Subject: email to Parish Council 25 November Minor Amendments Lanes End WA/7/19/RES

Comments on Option Unit 6

PJ DEVELOPMENTS LTD 2 Square Chambers 23 High Street Emsworth PO10 7AQ Tel: 0843 289 3430 Email: enquiries@pjdevelopmentsltd.com	
PROJECT: FORMER LANES END	
SITE PLAN OUTLINE PLANNING APPLICATION	
DATE: JANUARY 2019	DWG. NO 19-001 PL02
SCALE @ A1: 1:200	
REV: C

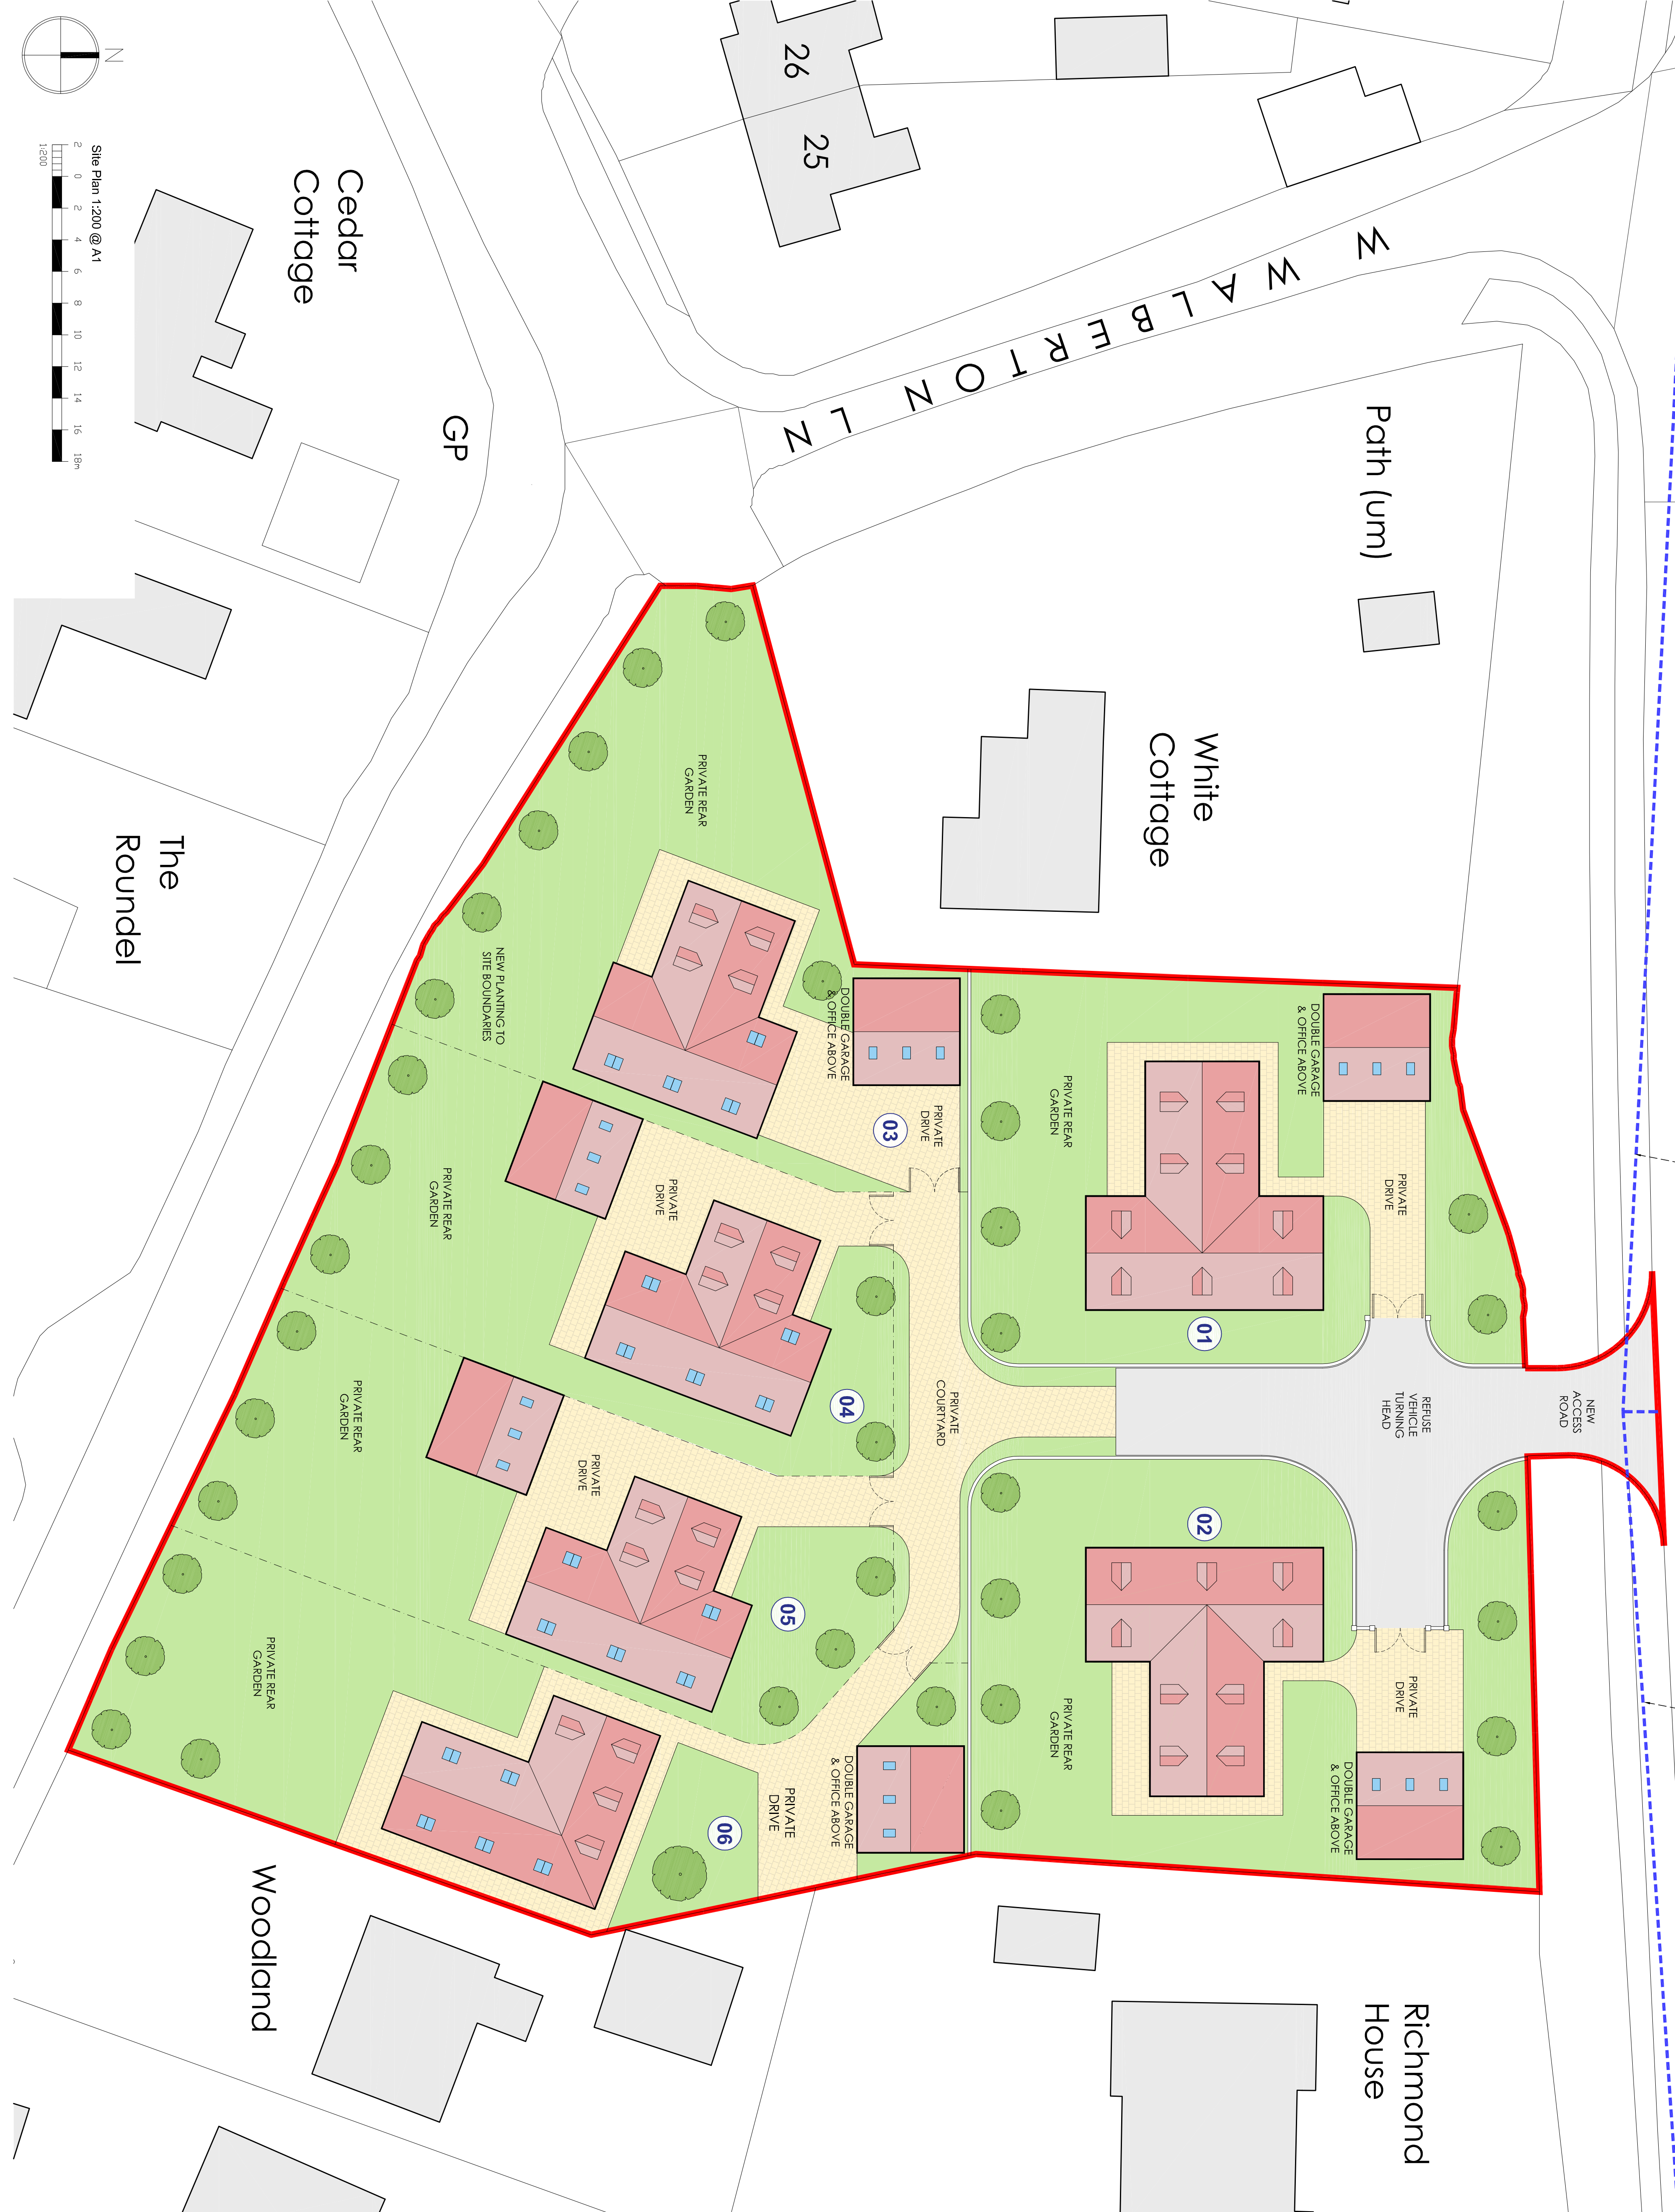
1. The view from Woodland would be badly affected. The existing Lanes End house is c40 metres from the boundary, but the unit 6 is less than 5 metres.
2. The size and closeness of unit 6 would mean a major loss of natural light in Woodland, our house, and would cast a large shadow over Woodland, its patio, conservatory and gardens on sunny afternoons
3. Most unit 6 windows will probably be on the wall facing Woodland, and more than on previous plans. These windows should be obscured glass and non-opening, to protect privacy of Woodland occupants.
4. Surface water run-off from the building will have an immediate effect on Woodland property.

1. The moving of unit 6 south from the outline plan position to the now proposed position shortens the garden length, and will badly affect its use as there are 2 trees with TPOs at the southern end of the plot.

2 Being so close to Woodland house would mean a major loss of privacy in unit 6.

It would be better for everyone to move unit 6 further North and turned slightly as shown on attached drawing A&V dated 1.12.2019 – nearer the position in the approved outline Block Plan. This removes most overlooking and privacy loss in both directions.
